<b>Consultation Response from KC, Highways Development Management</b>
<b>2024/92236 Wood Street Mills, Wakefield Road, Scissett, Huddersfield, HD8 9JS</b>
<b>Demolition of existing industrial building and erection of storage and distribution building with car park and associated engineering works</b>
<b>Date Responded: 28/10/2024 Responding Officer: CNB Responding Ref: K17-30/11</b>

Title:  
Proposed Site Plan (Floor Plan)

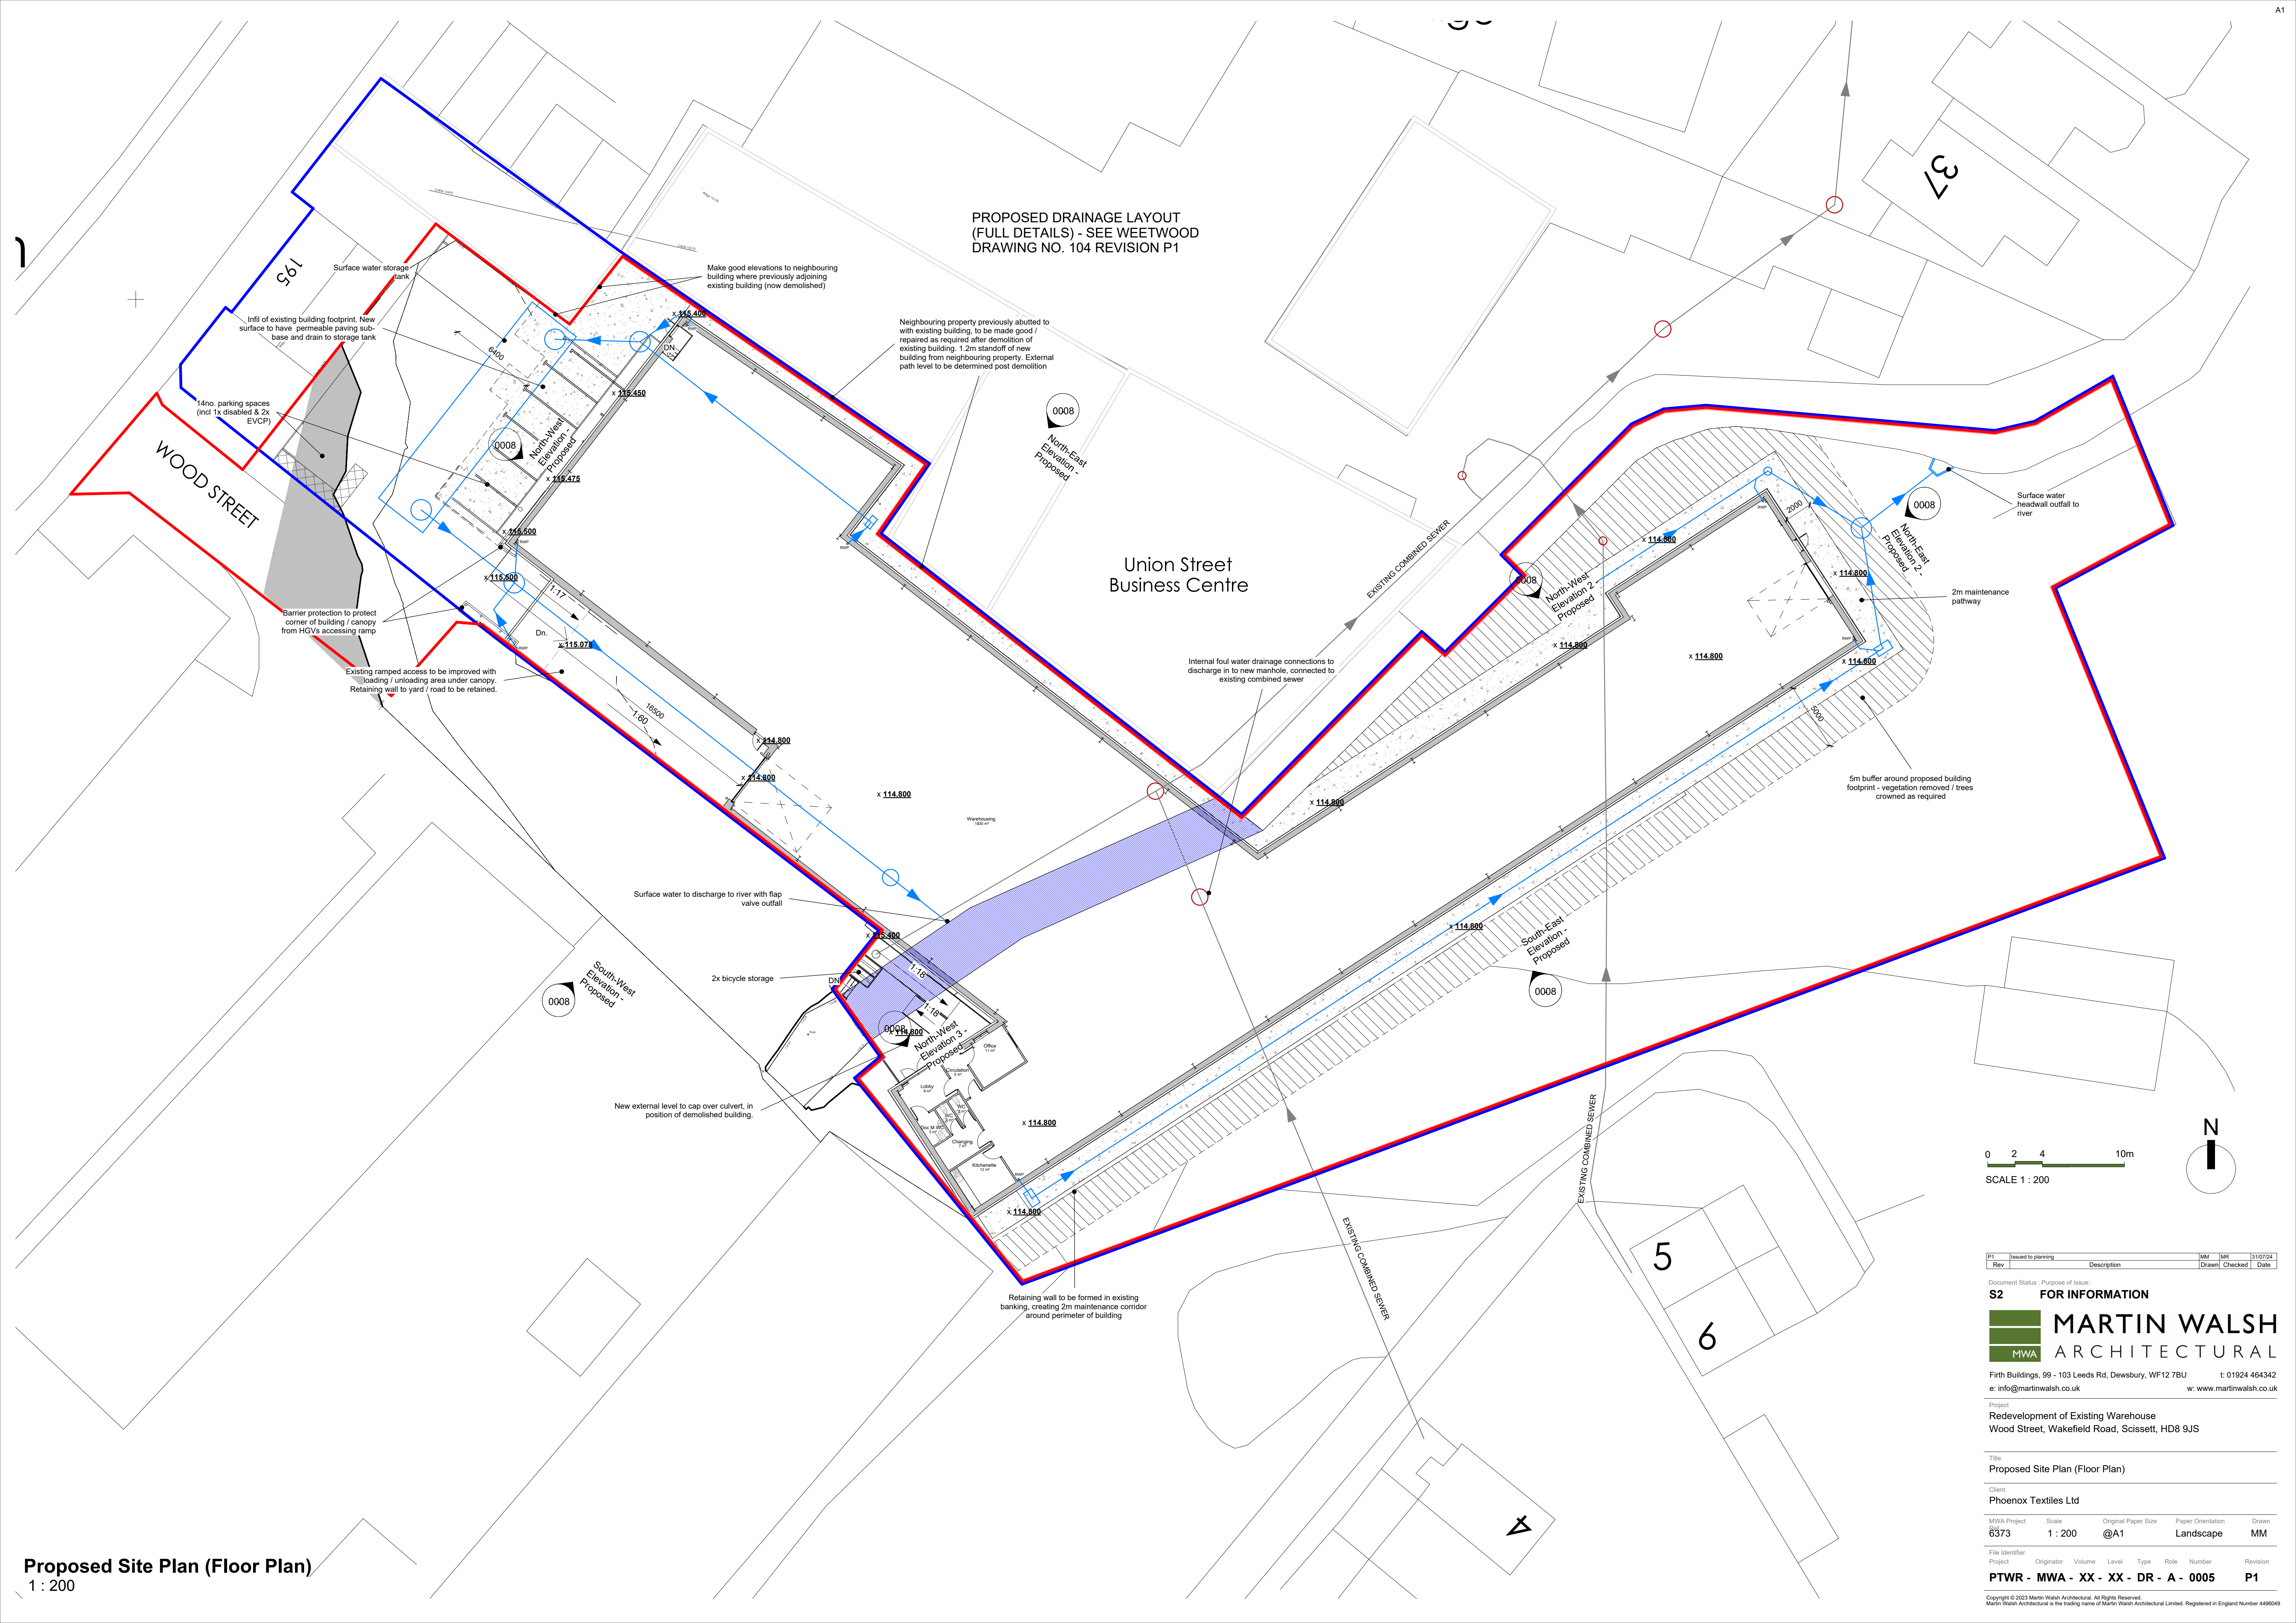
The increase in formalised car parking is acceptable.

The delivery access is to remain in the same location as the existing, however there was no indication as to if the changes to the car parking area to the front of the proposal building will have an impact on delivery vehicle manoeuvring. Due to this we would like to see a swept path tracking analysis showing that an expected sized delivery vehicle can safely manoeuvre and turn within the site, and this should be added as a pre-occupation condition.

Notwithstanding the details shown on the approved plan, no development shall take place until a scheme detailing arrangements and specification for vehicular access, consisting of a swept path analysis for vehicles using the loading bays, has been submitted to and approved in writing by the Local Planning Authority.
